Planning Application Reference No.: 3/2022/0190

Address of Development: Elmridge Barn, Elmridge Lane, Chipping, PR32NY

PROPOSED PLAN
SCALE 1:200

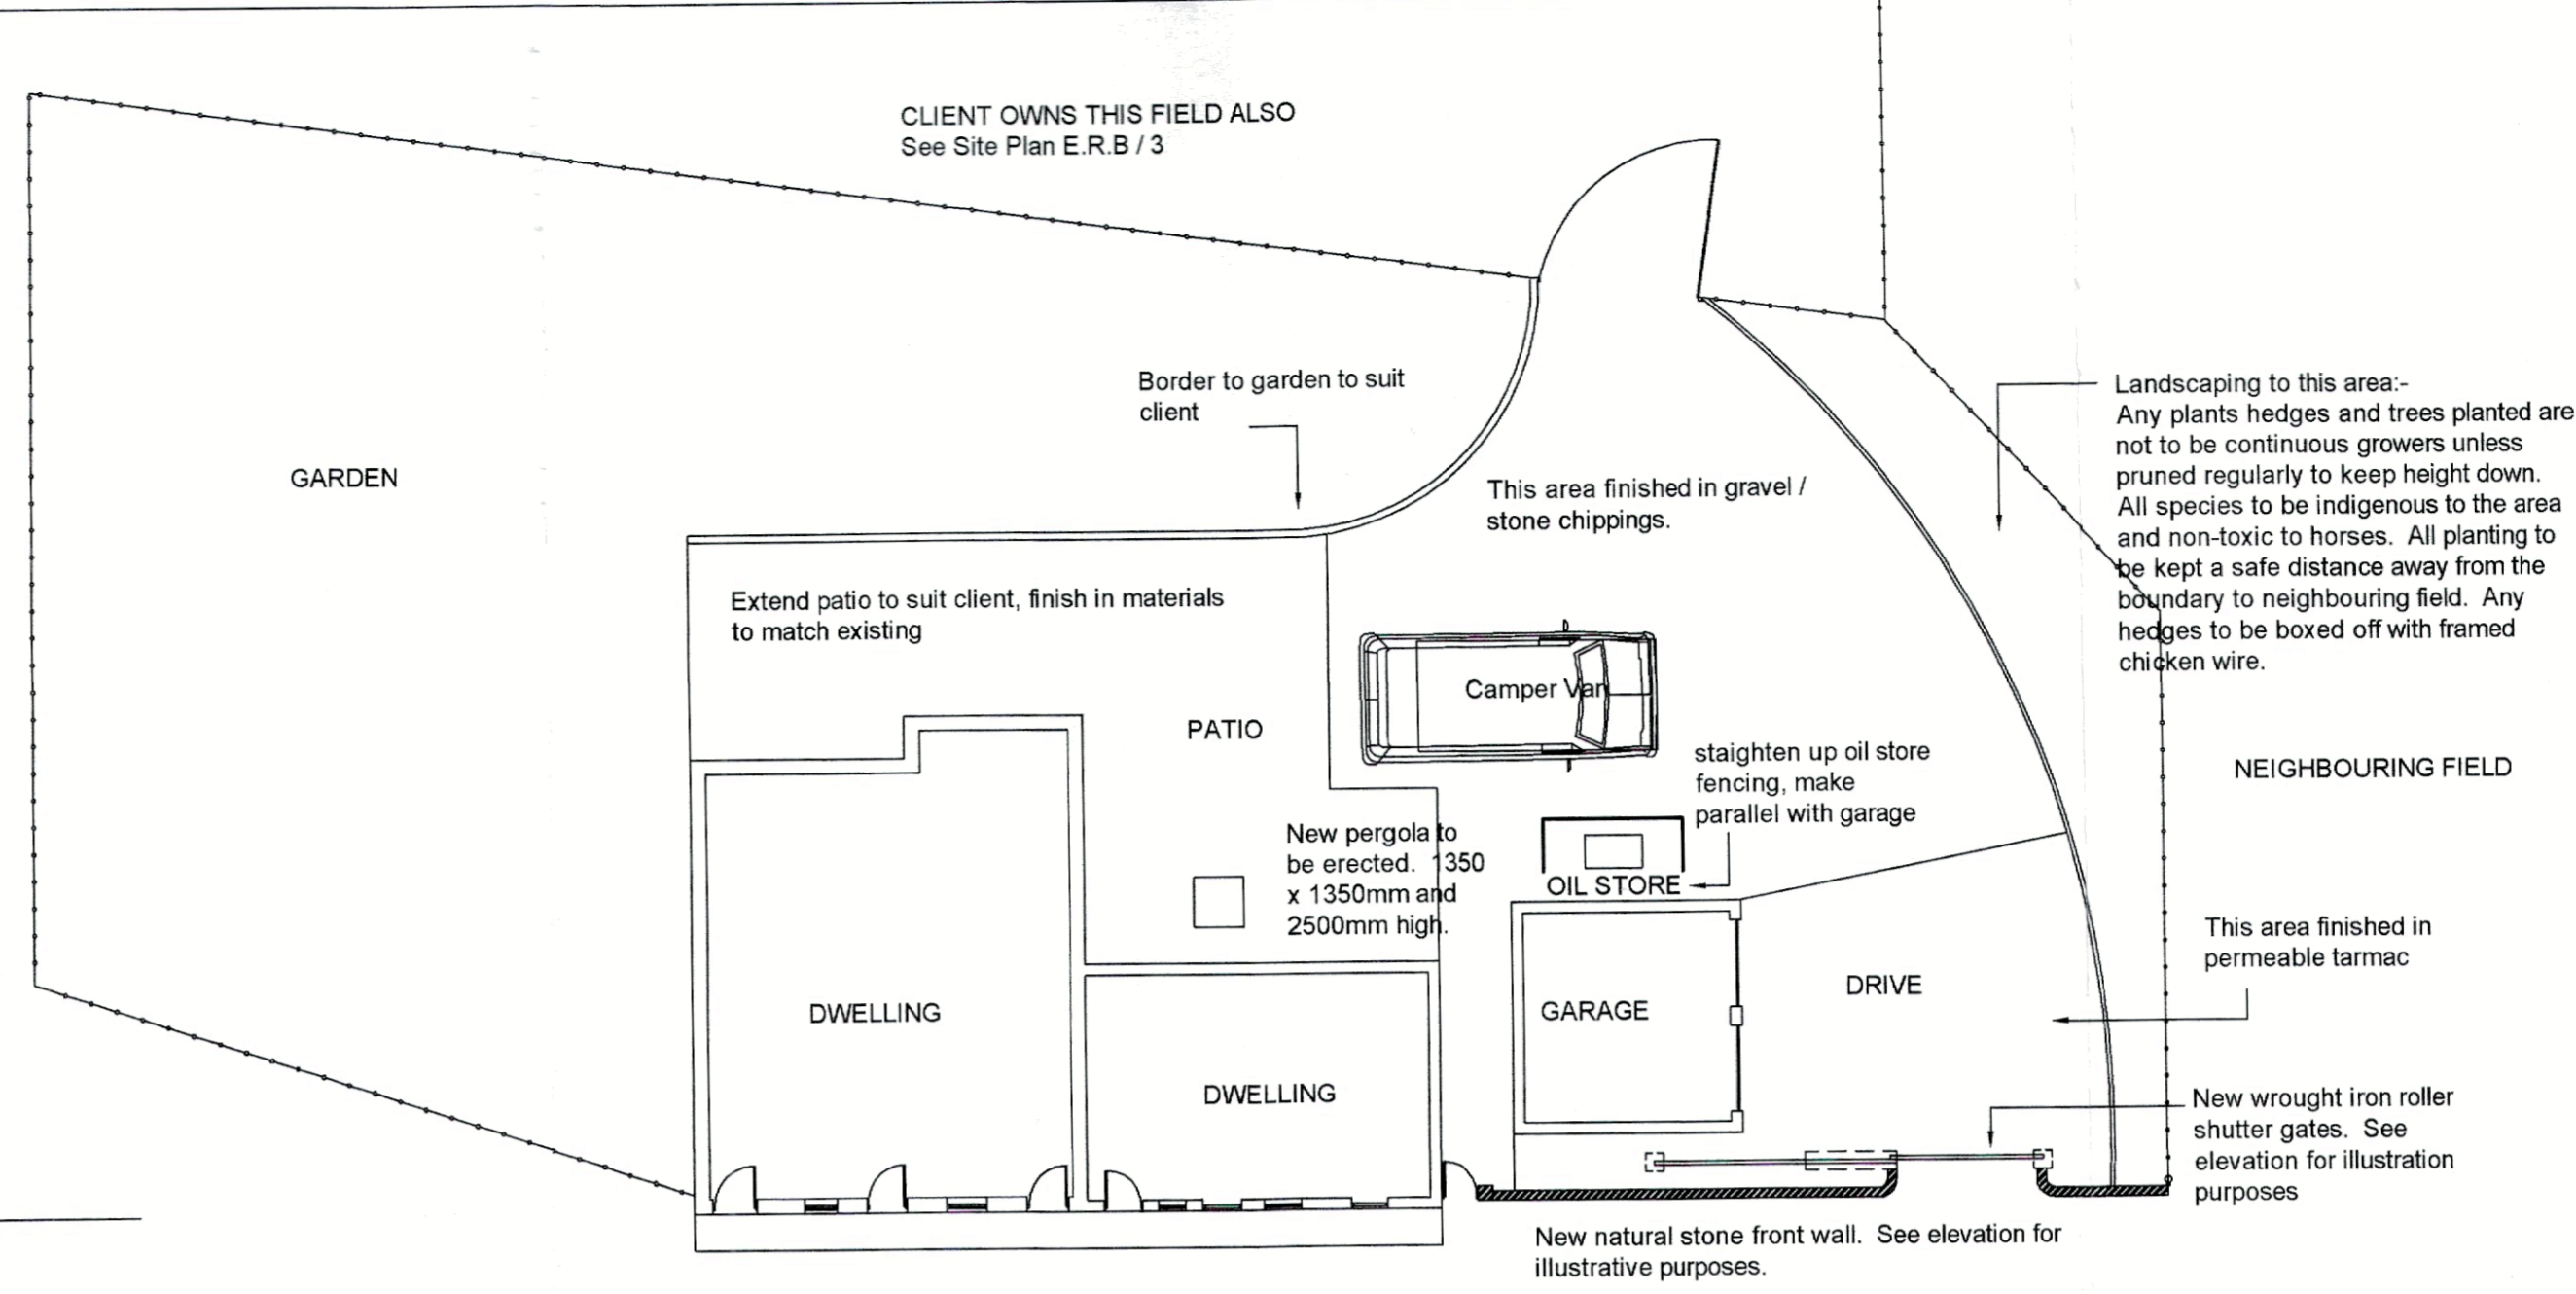
The pergola must be behind their property so [REDACTED] however the potential issue is the camper van is to be kept behind the oil tank and close to oil tank, again so it is out [REDACTED] this is in the covenant. Again to protect the view. If the pergola is 1350mm away from their property, depth and width it will then push the camper van further out into the garden and it will be visible [REDACTED] unless the width of the pergola can be made smaller and therefore will allow the van to be kept tight and behind the oil tank, in its original position of course, as intended in the original plan and covenant.

Hedging/planting on the right hand side of the application [REDACTED] needs to be kept within this height, and ideally away from the fence to protect horses or grazing animals [REDACTED]

PROPOSED FRONT ELEVATION
SCALE 1:100

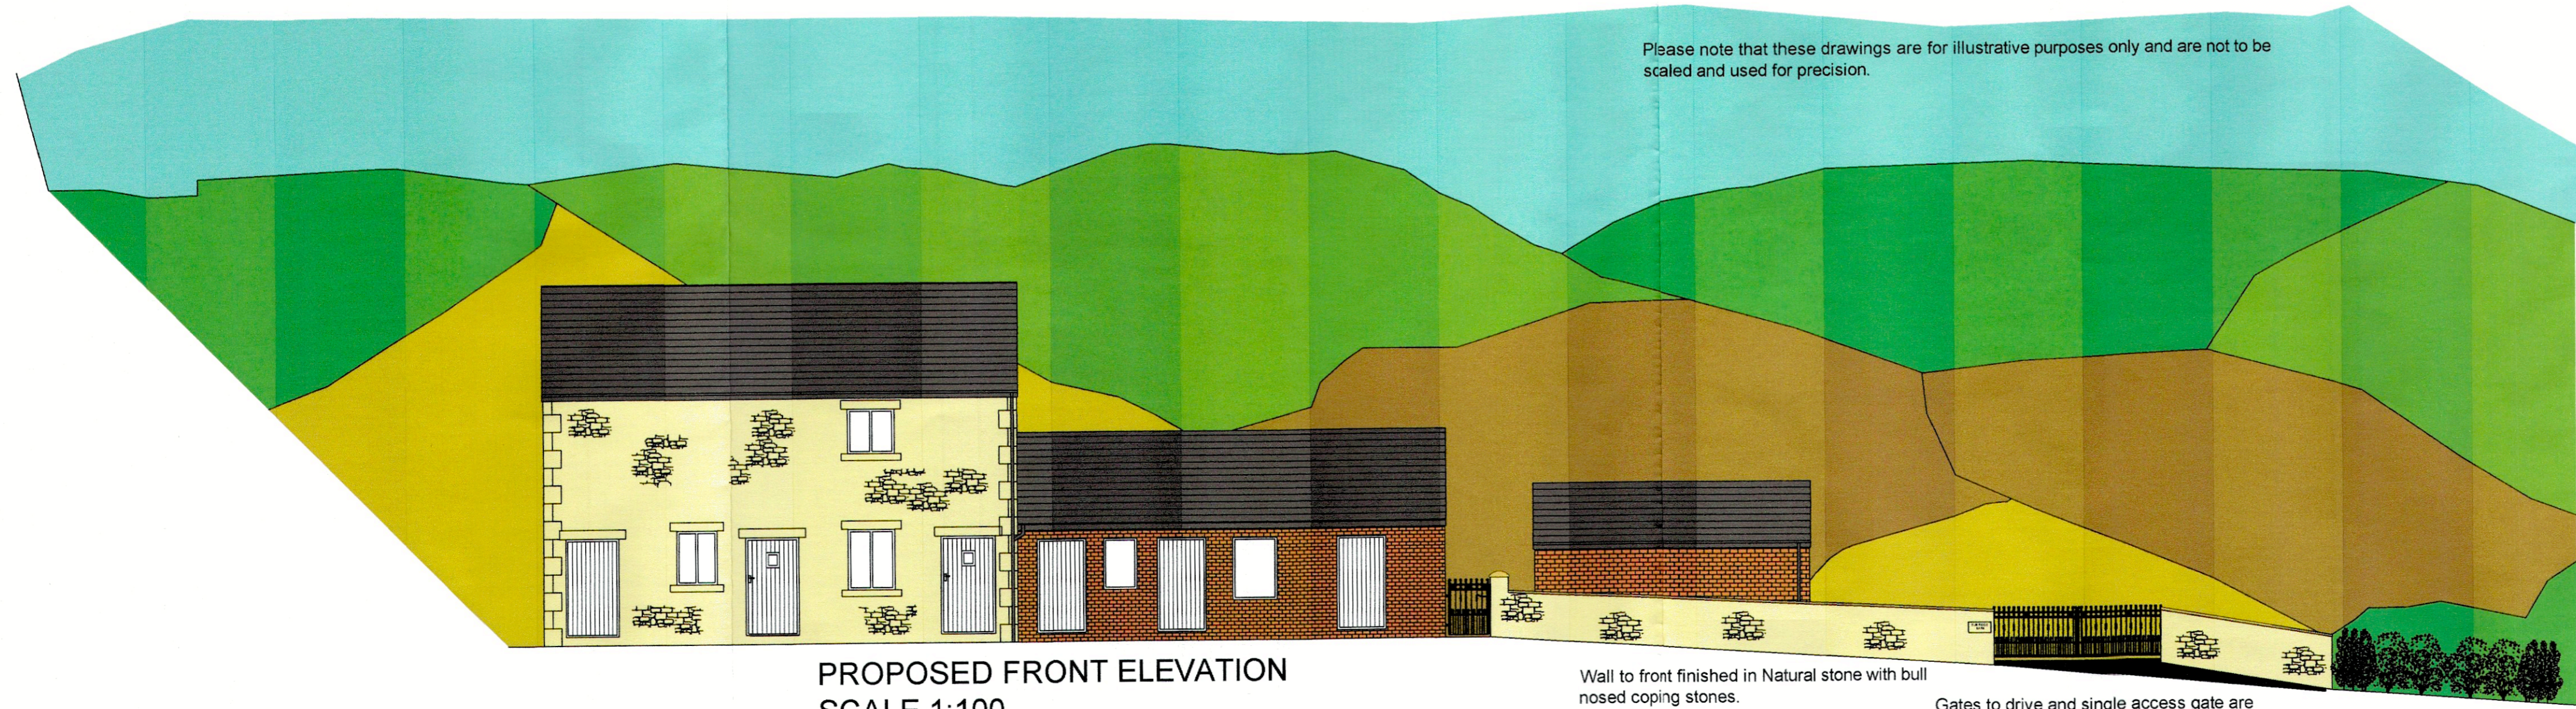
Comments: There is a covenant on Elmridge Barn property(the planning application property) protecting the view and outlook [REDACTED] This is due to this property being in front of the other three properties on the site. NO trees/hedging etc or any structure to be above 1220mm to be erected.

The gates and wall again need to be kept within the covenant height to protect the house view now and in the future, as it was intended to do, otherwise no issue
